National Highways Planning Response (NHPR 21-09) Formal Recommendation to an Application for Planning Permission

Council's Reference: 21/03267/OUT

Location: OS Parcel 0006, southeast of Baynards House Adjoining A43, Baynards Green

National Highways Ref: 92857

BOUNDARY SECTIONS 11-15

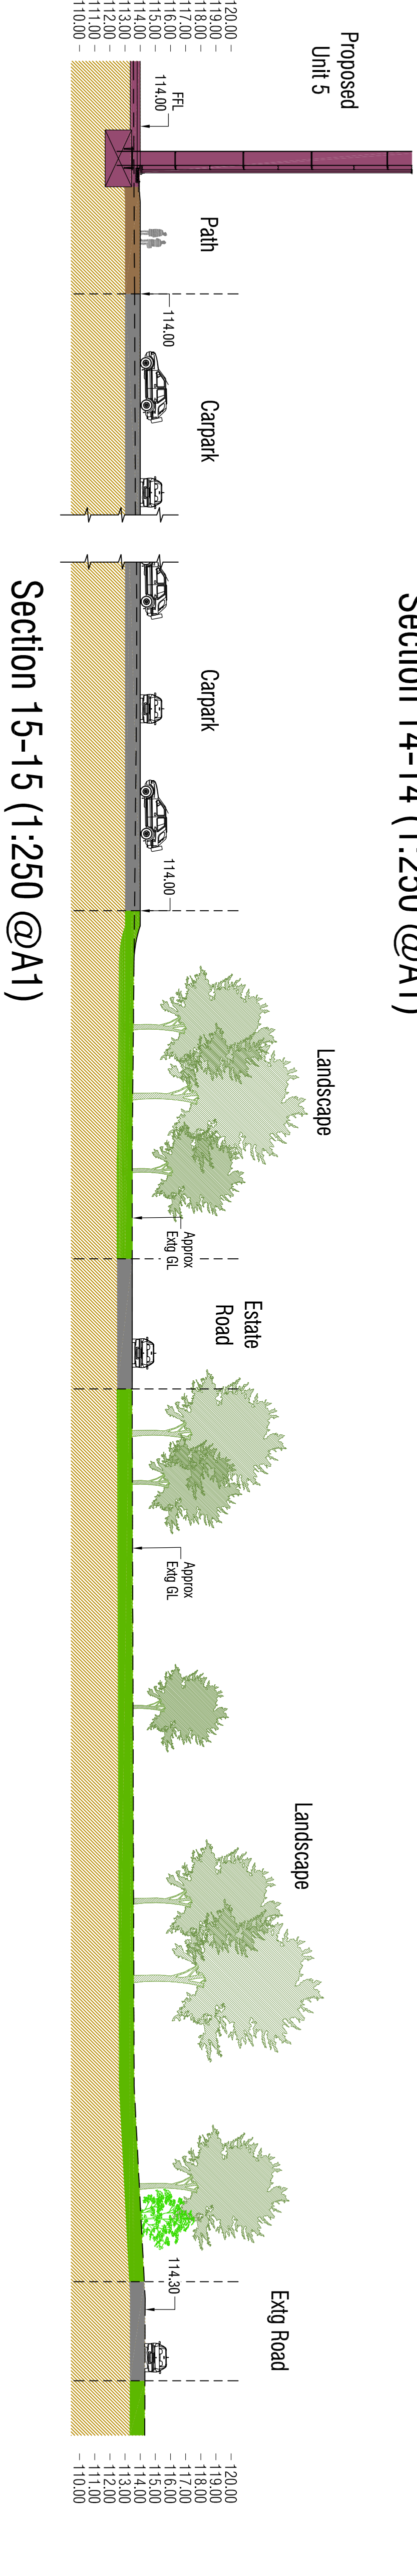
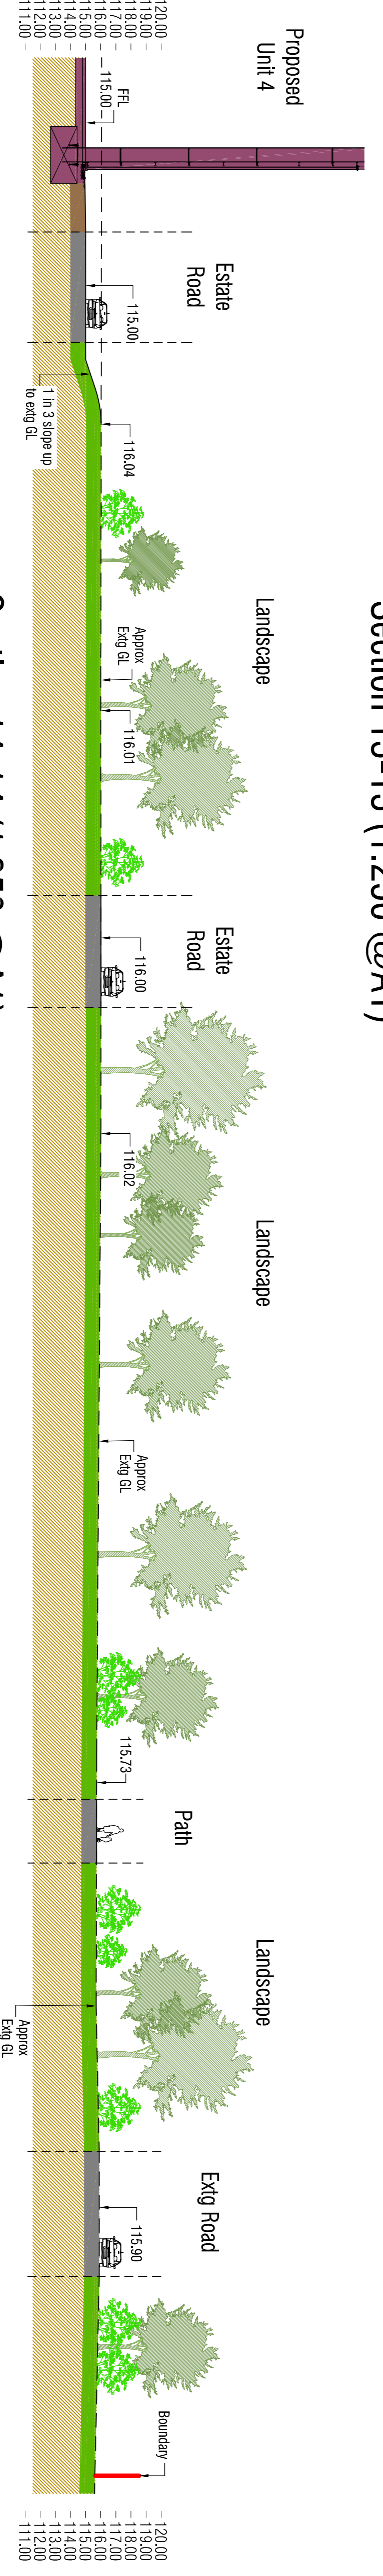
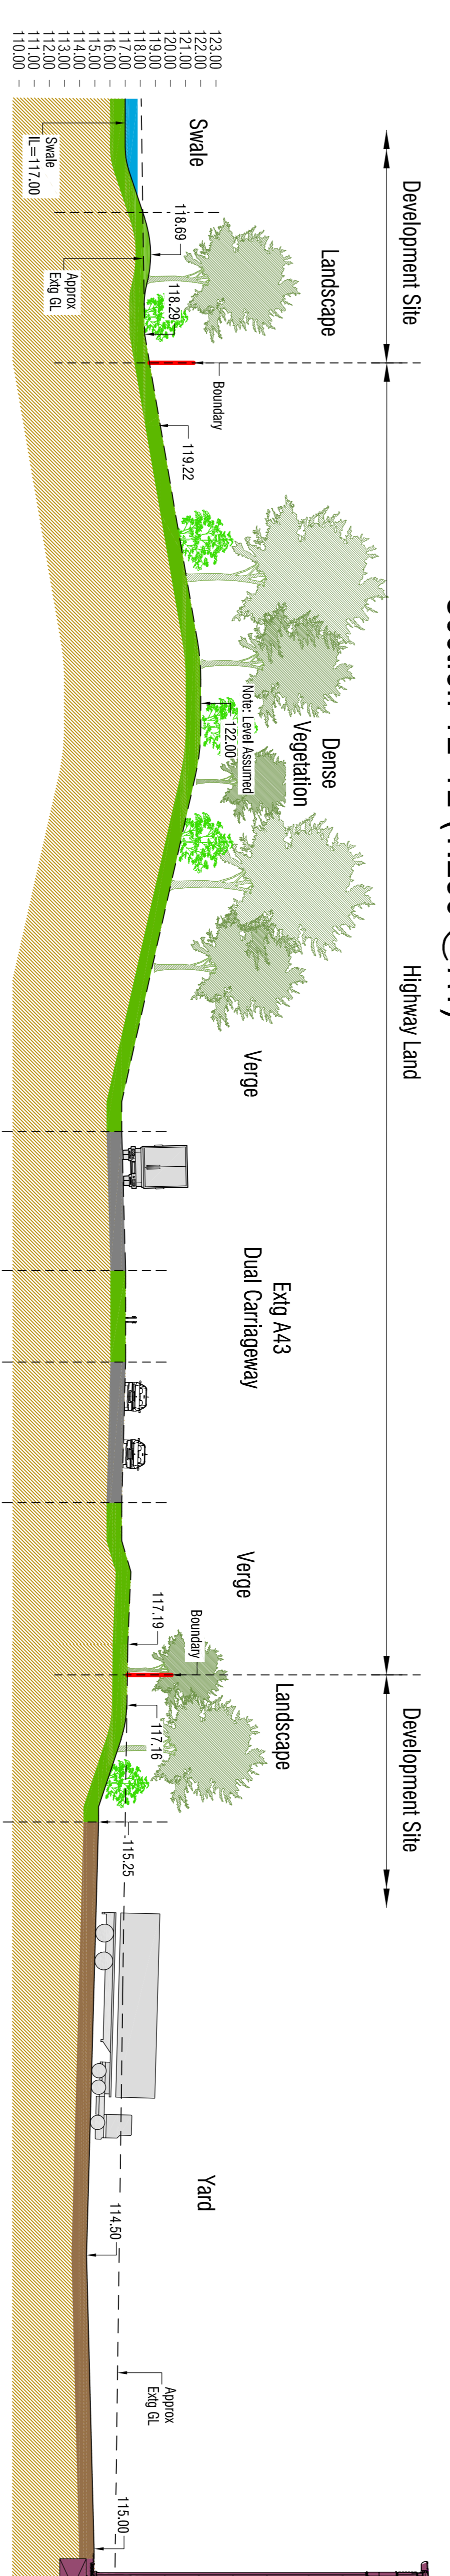
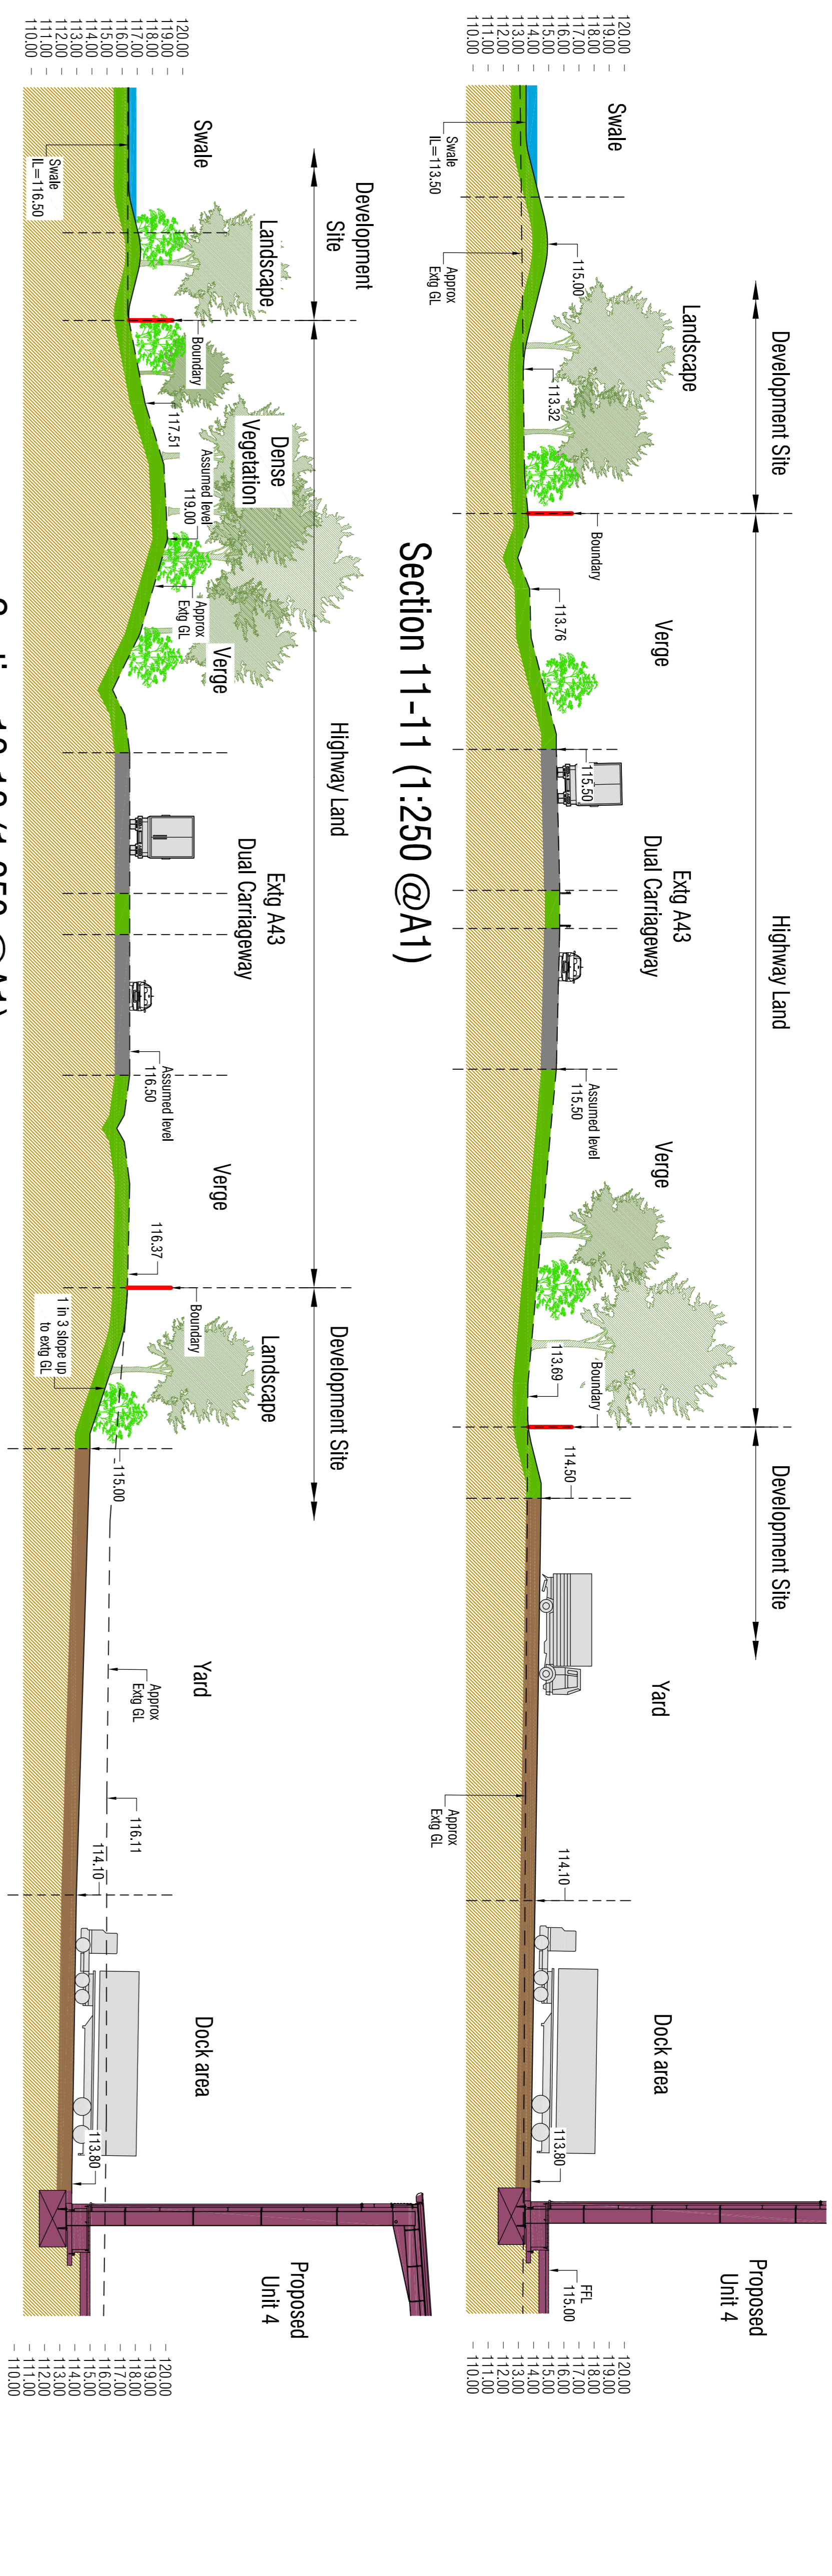
The applicant will need to advise / confirm if there will be any earthworks associated with the development(s) in relatively close proximity to National Highways boundaries (e.g. the stability of the balancing ponds, etc). In the first instance, some cross sections (to scale) through the boundaries showing the proposed extent of the development, its features and any proposed changes in elevation (excavations, landscaping) etc should be submitted for further assessment. Once received, we will review to determine the possible extent of any geotechnical reporting under the Design Manual for Roads and Bridges (DMRB) standard CD 622, which may be required to confirm the extent of any geotechnical risk to the SRN.

JOB TITLE		M40 JUNCTION 10		CLIENT		ALBION LAND	
DRAWING TITLE							
EASTERN ACCESS GENERAL ARRANGEMENT PRE-GROWTH FUND SCHEME							
SCALE	DRAWN BY	DATE	DRAWING No	REVISION			
1:500@A1	RM	03/08/21	17213-16-GA	P0

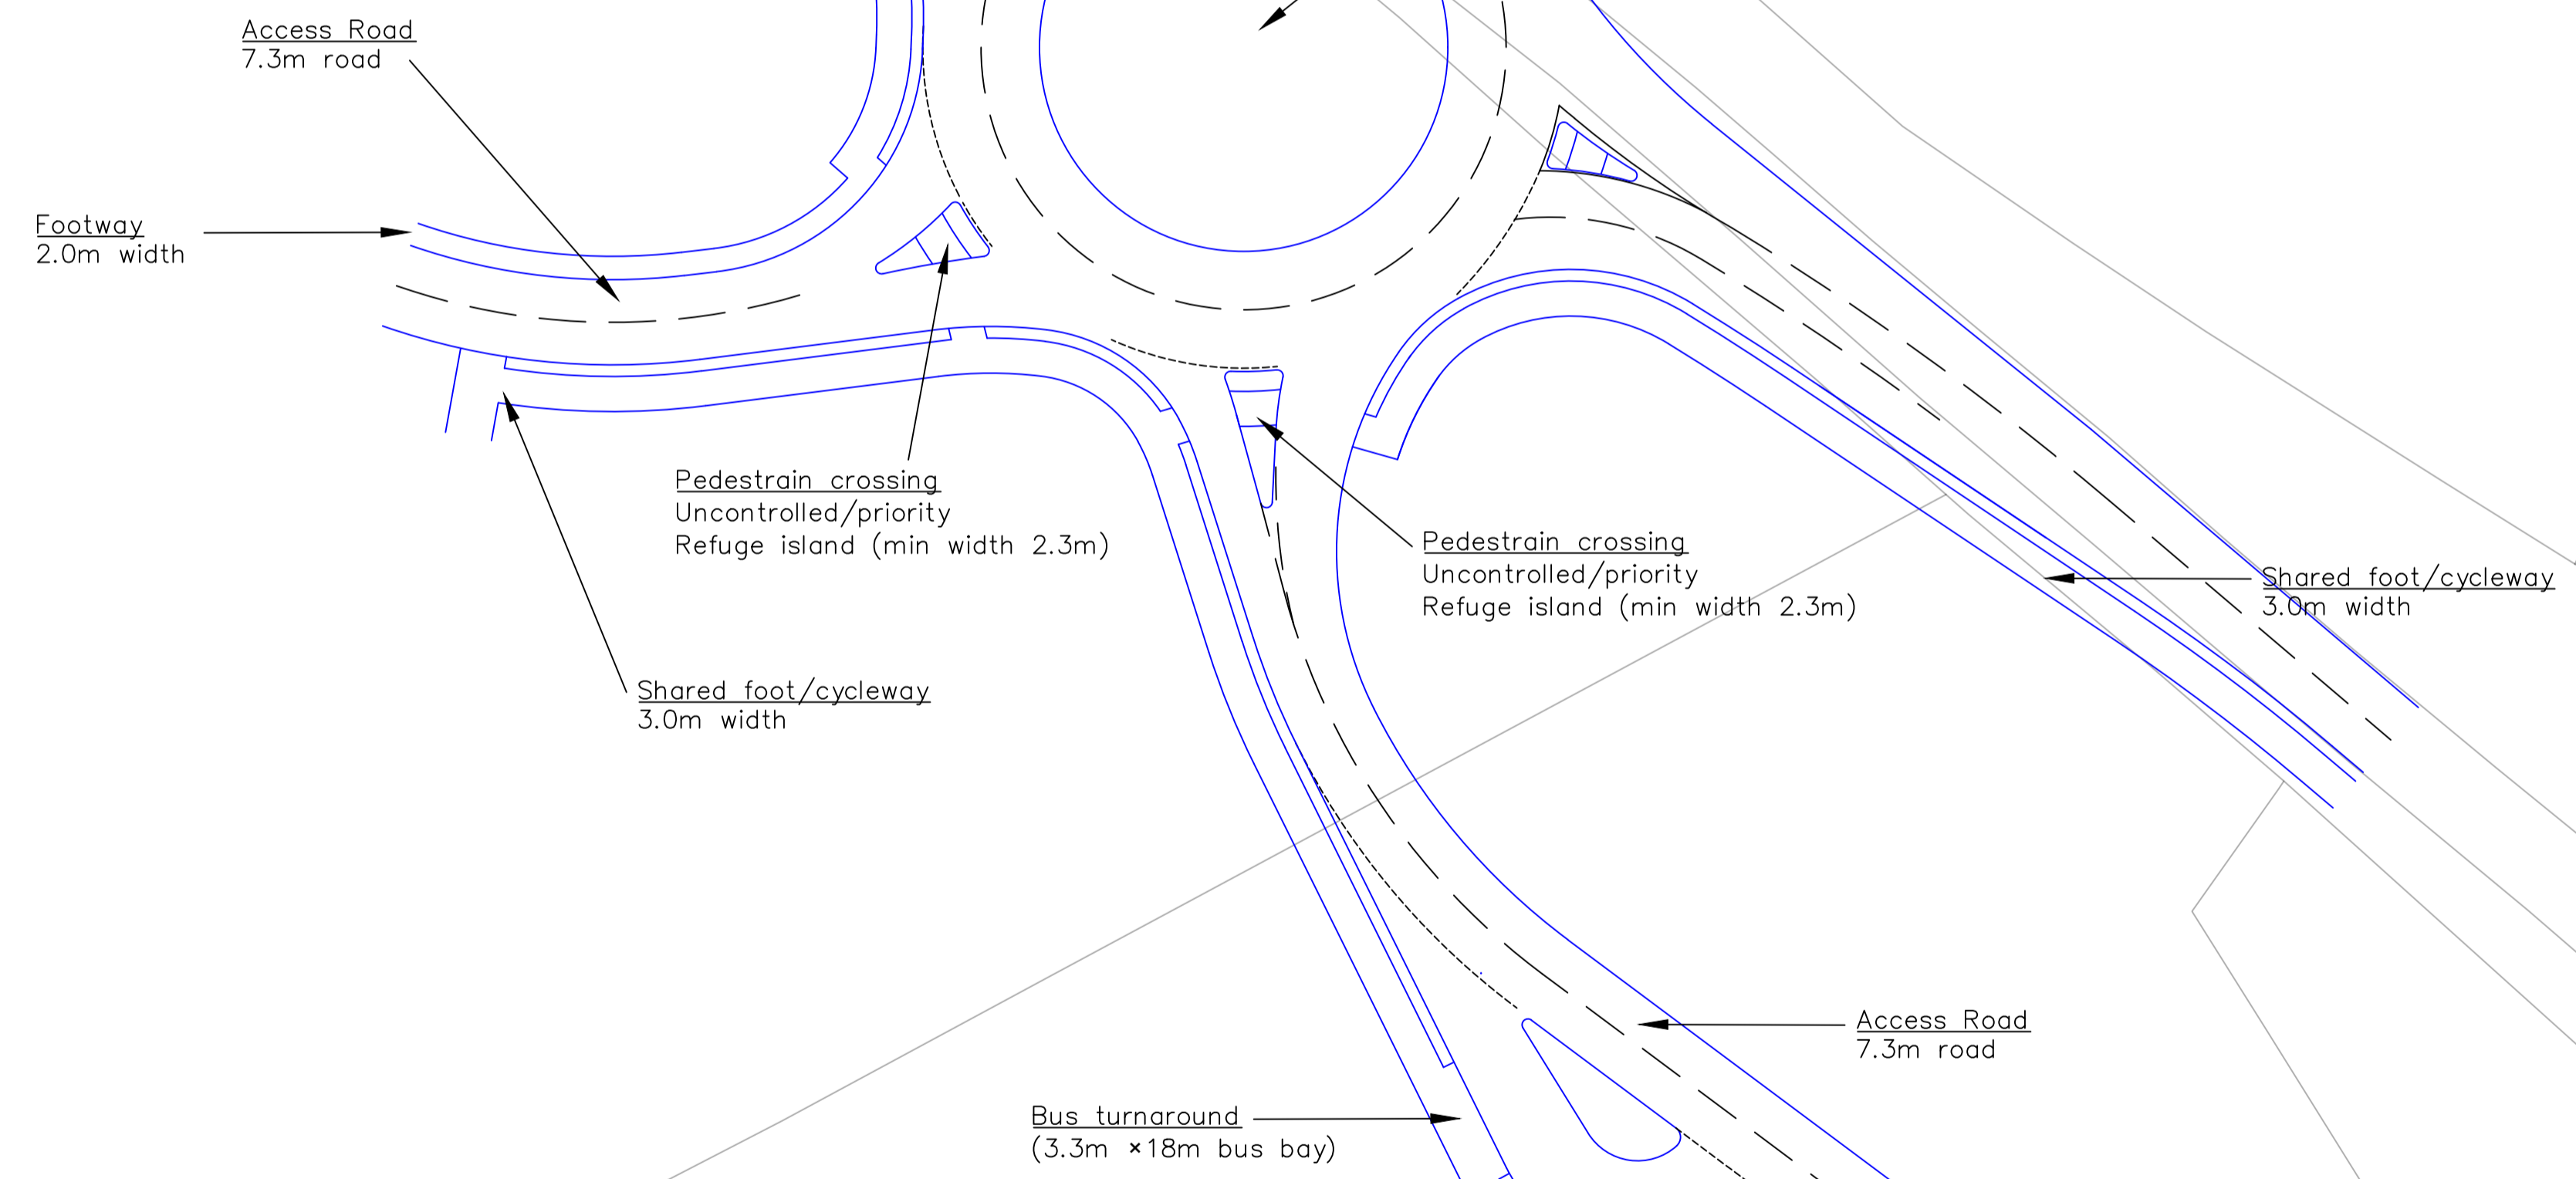
The applicant has proposed an interim mitigation scheme at the A43 Baynards Green roundabout which includes widening of the B4100 entries and a standalone signal-controlled toucan (pedestrian and cycle) crossing.

As there remain outstanding concerns, and the proposed improvement scheme as part of the Growth Deal scheme at the A43 Baynards Green roundabout and M40 J10 has not been modelled into the assessments, National Highways is not in a position to comment on the suitability of the interim mitigation scheme.
